KINCOPPAL ROSE BAY SCHOOL

SUPPLEMENTARY TRAFIC REPORT
FOR PROPOSED ALTERATIONS
AND ADDITIONS TO KINCOPPAL
SCHOOL, ROSE BAY

RESPONSE TO MATTERS RAISED BY
AUTHORITIES

JUNE 2021
(Modified 17 June 2021)

SITE - EXISTING CARPARK PLAN

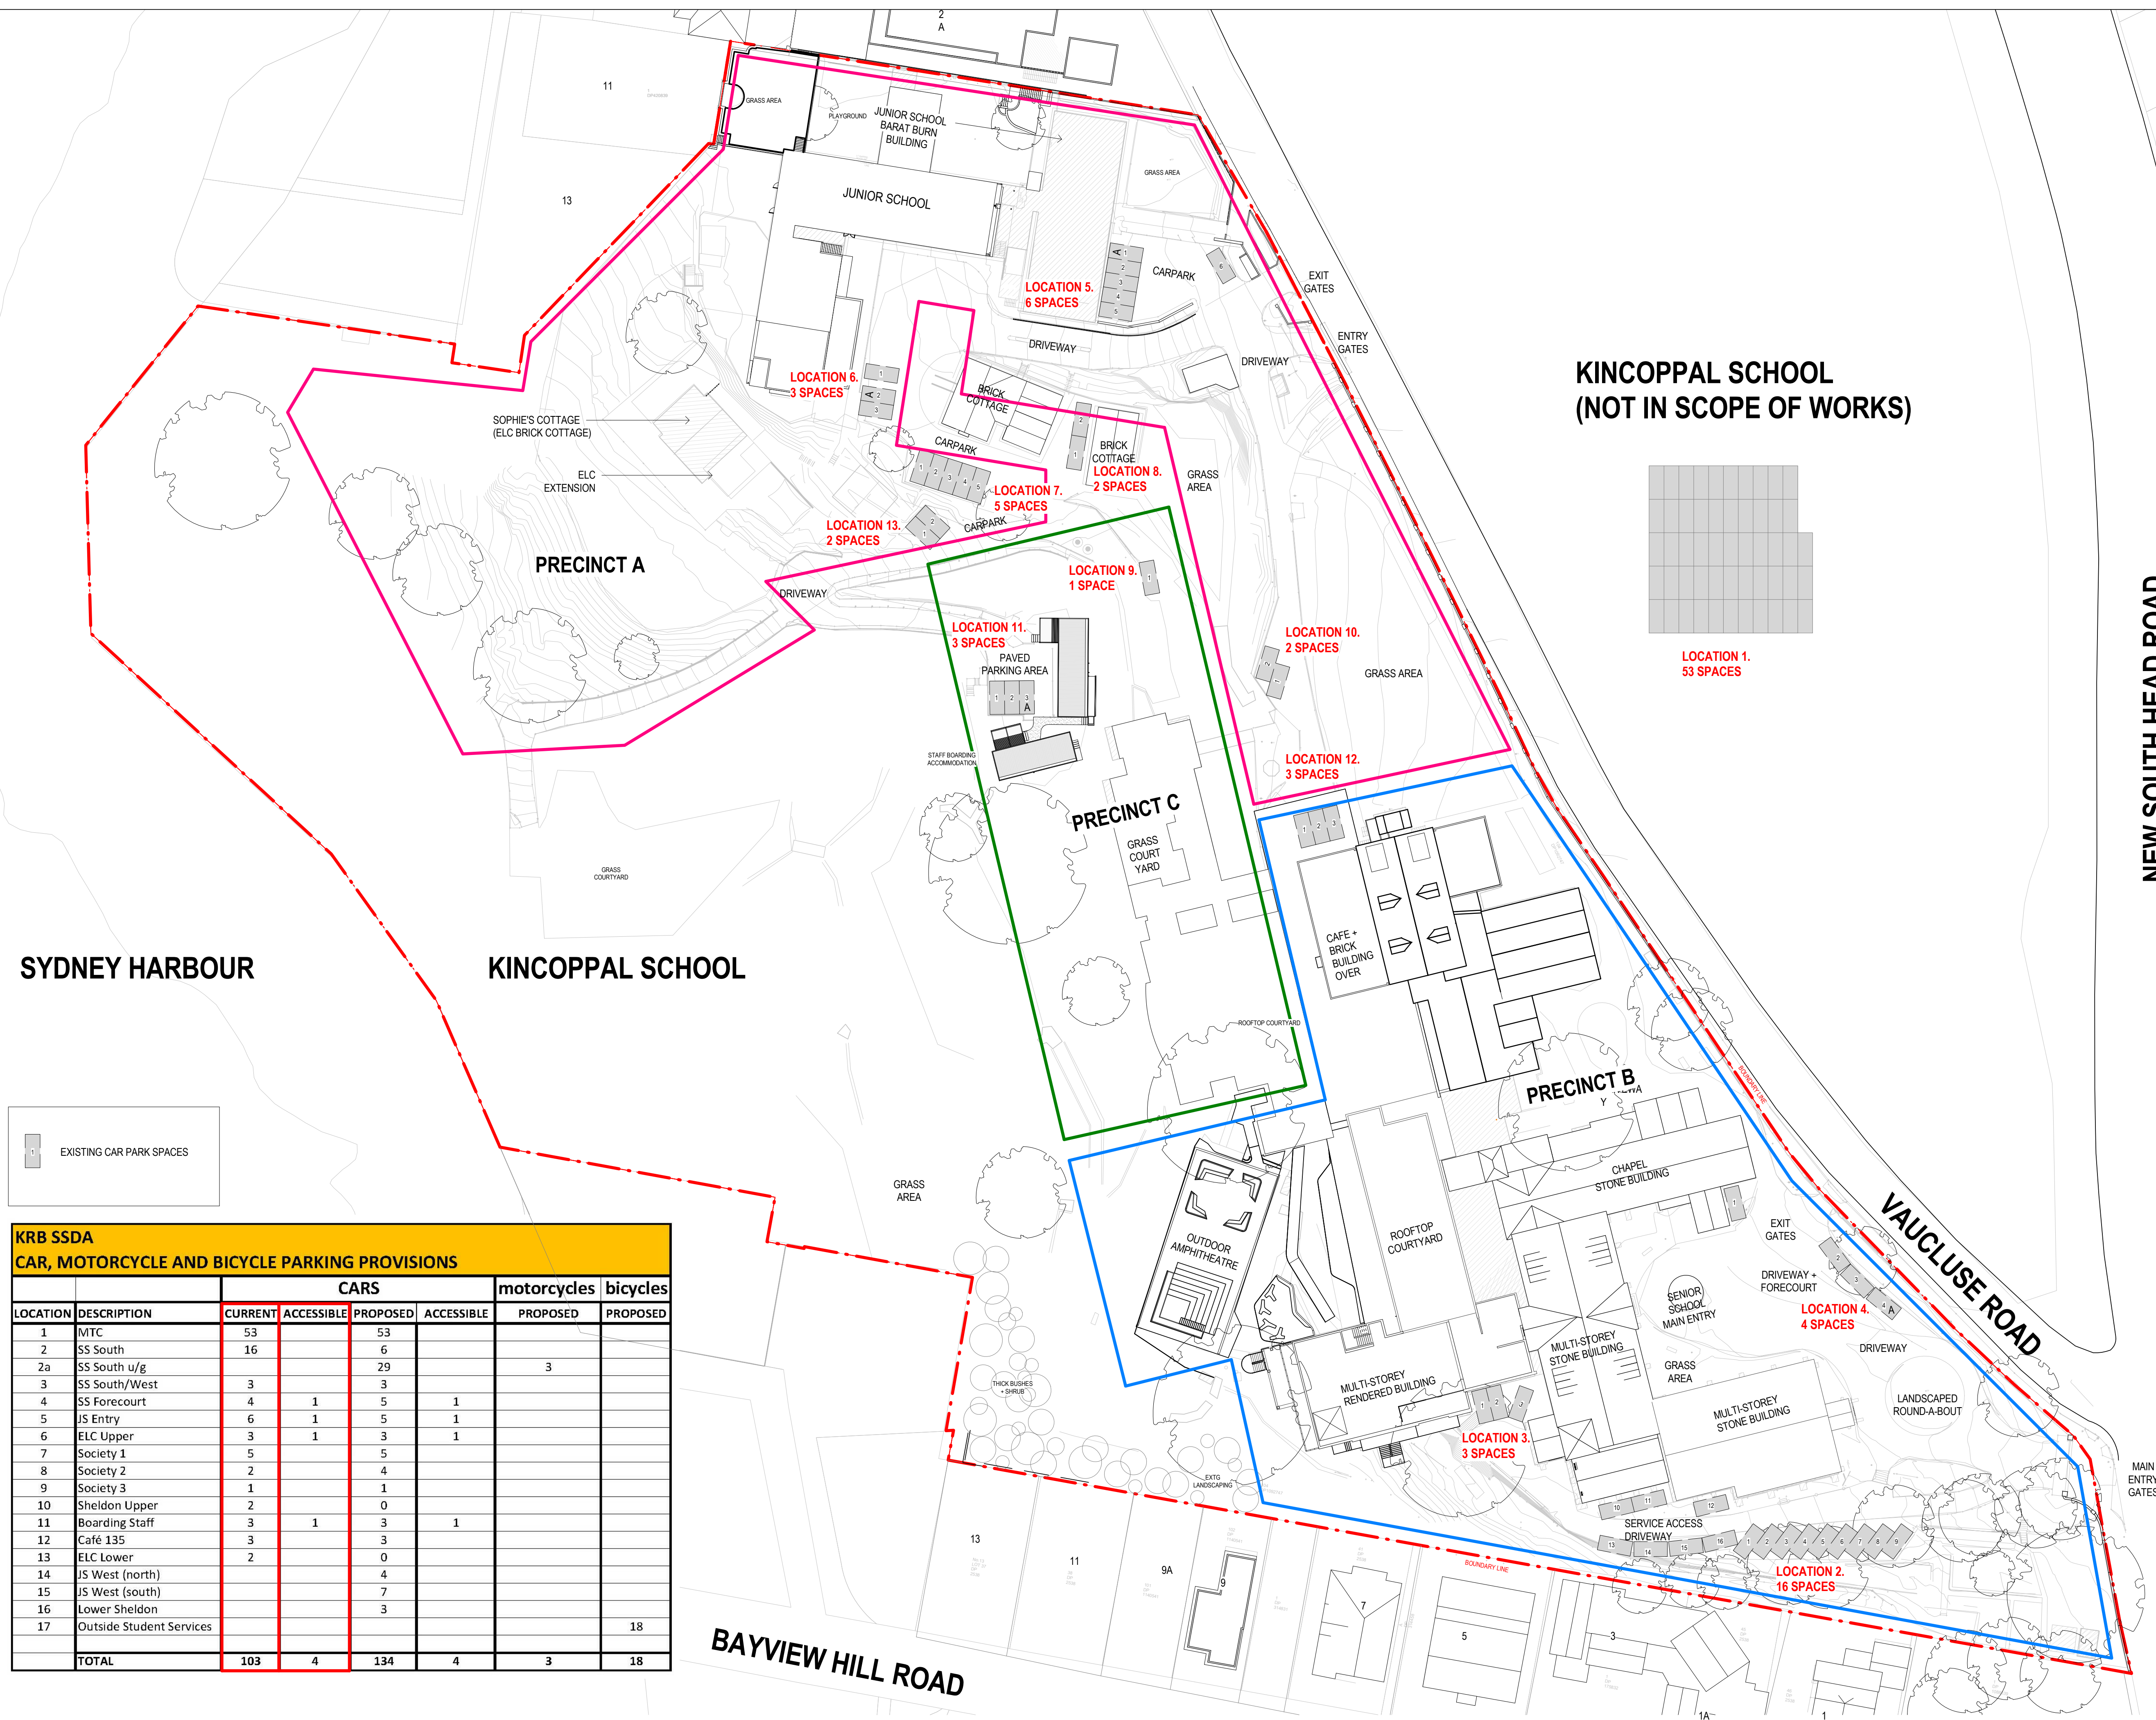
- i. *There is a shortfall of at least three (3) car parking spaces, which in reality should be seven (7) according to the school survey, or more if the undersupply of the existing parking provision is considered;*

- 2.25 In accordance with Council's DCP requirements, the proposed alterations and additions to the school will provide an additional 31 on-site parking spaces for staff and visitors. The architectural plans have been amended to include the required additional parking spaces.

- 2.26 The school will ultimately provide a total of 134 parking spaces (including four accessible parking spaces), three motorcycle spaces and 18 bicycle parking spaces, as shown on Figure 11.

- 2.28 During the early stages of the development, prior to the construction of the new basement car park, additional at-grade car parking spaces will be provided. These parking spaces will form part of the required additional 31 parking spaces and will be located follows, as shown on Figure 11:
-

-
-
- Location 8 - additional 2 spaces;
 - Location 14 - additional 4 spaces;
 - Location 15 - additional 7 spaces; and
 - Location 16 - additional 3 spaces.
